Our Case Number: ACP-322845-25

Re: Proposed development of 11 wind turbines and ancillary development within the townlands of Ballynamullagh, Kilmurry, Coolree, Killyon, Mulgeeth and Drehid, County Kildare (www.drehidwindfarmSID.ie)

Your Ref: ACP-322845-25

Proposed Strategic Infrastructure Development (SID): Development consisting of 11 no. turbines (and all associated works) in the townlands of Ballynamullagh, Kilmurry, Coolree, Killyon, Mulgeeth and Drehid, County Kildare

TITLE: Breeding/Wintering Bird Survey Transects	
PROJECT: Drehid Wind Farm and Substation	
FIGURE NO.: 2.2	
CLIENT: North Kildare Wind Farm Ltd.	
SCALE: 1:22,500	REVISION: 0
DATE: 15/05/2025	PAGE SIZE: A3

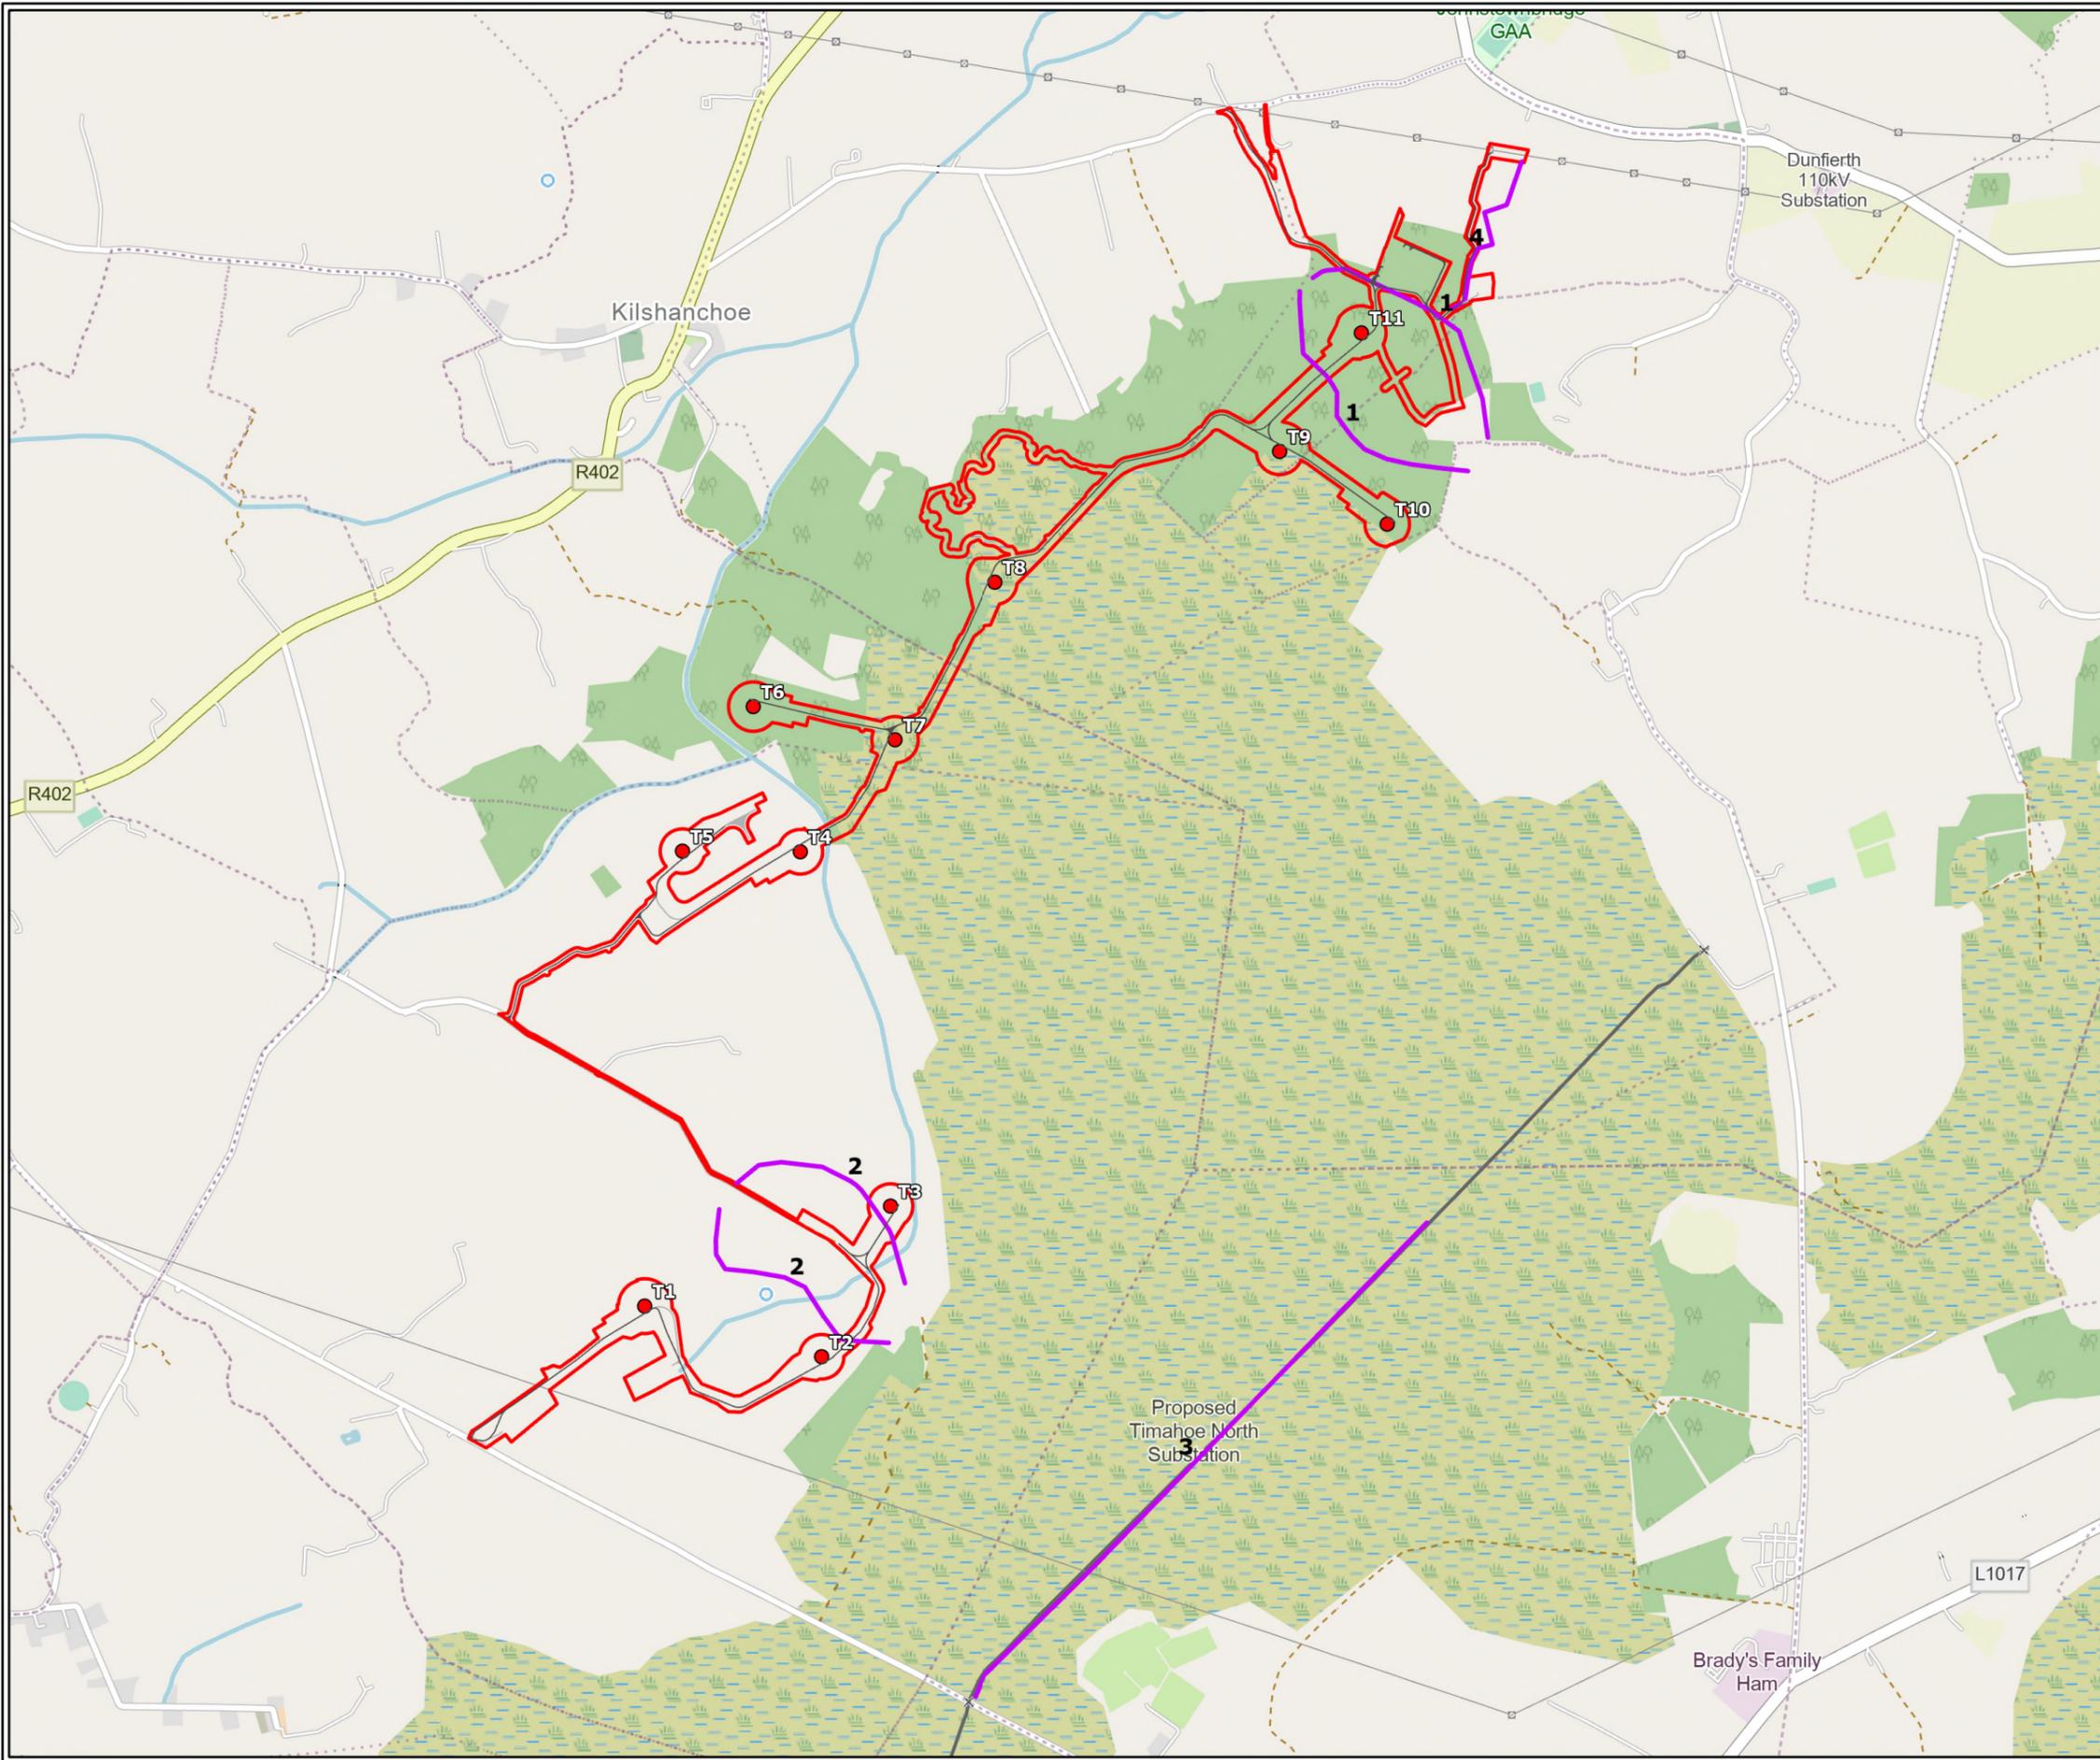
In addition, the transect surveys undertaken within the proposed development, only actually covered a very small portion of the site, as shown on Figure 8.2. This represents a significant gap in the baseline surveys, and the Department recommends that reasoning is sought as to the rationale behind this limitation. If no rationale can be provided, further surveys should be undertaken within the entire site.
